From: Bloomer, David <David.Bloomer@lancashire.gov.uk>
Sent: 21 December 2018 11:41
To: Robert Major
Cc: LHS Customer Service; planning
Subject: app3/2018/1067 The Outbarn, Clough Bottom, Bashall Eves

Dave Bloomer
Development Support
Lancashire County Council

| PROPOSED PLANS AND ELEVATIONS | |

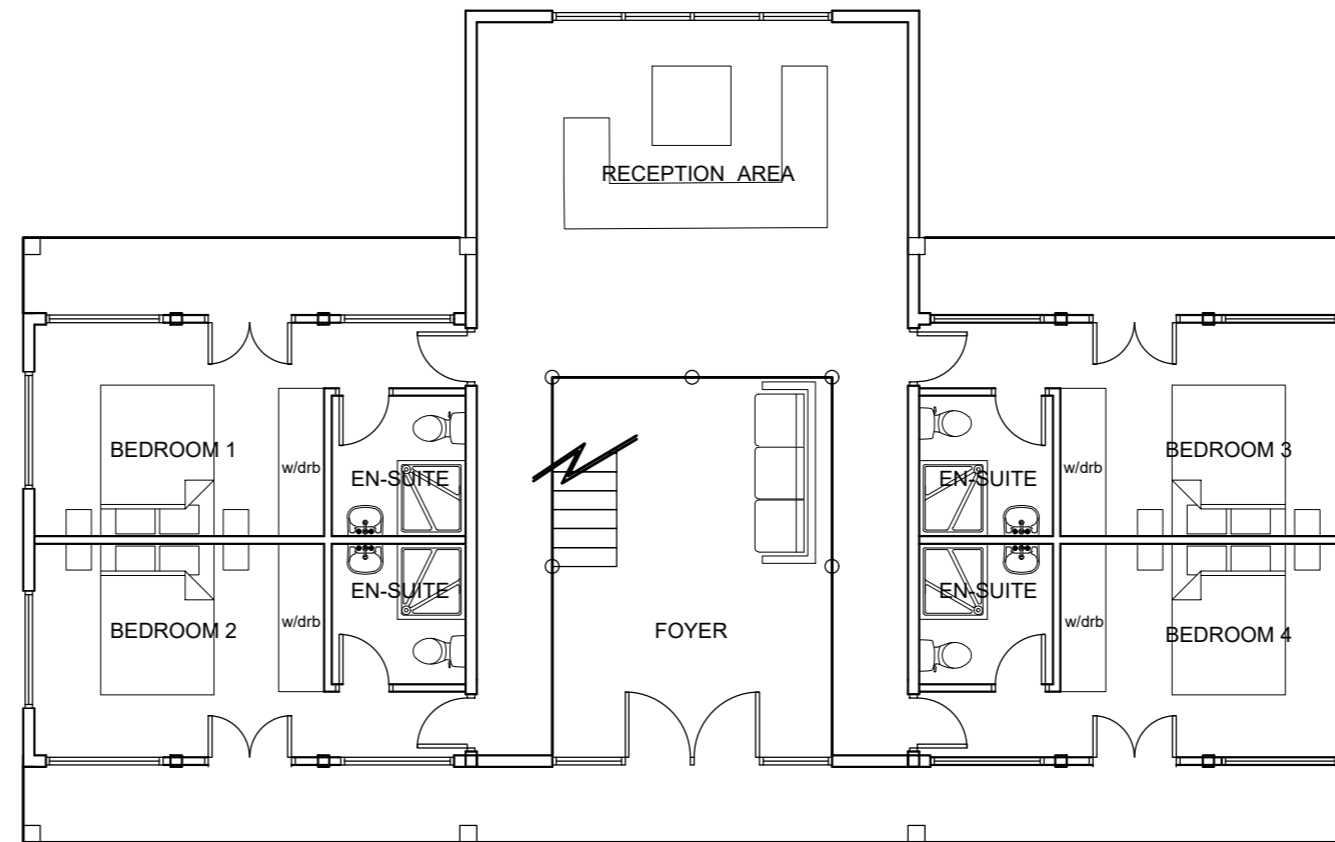
It is unclear from the application whether or not the accommodation proposed will be for the sole use of the wedding / training use of the site or for general holiday use. It is noted that the floor plans for the proposal do not include any kitchen or food preparation areas. It is important that this distinction is made due to the traffic generating potential of a standalone holiday facility. My preference would be for the accommodation to be conditioned to be ancillary to the existing assembly uses.
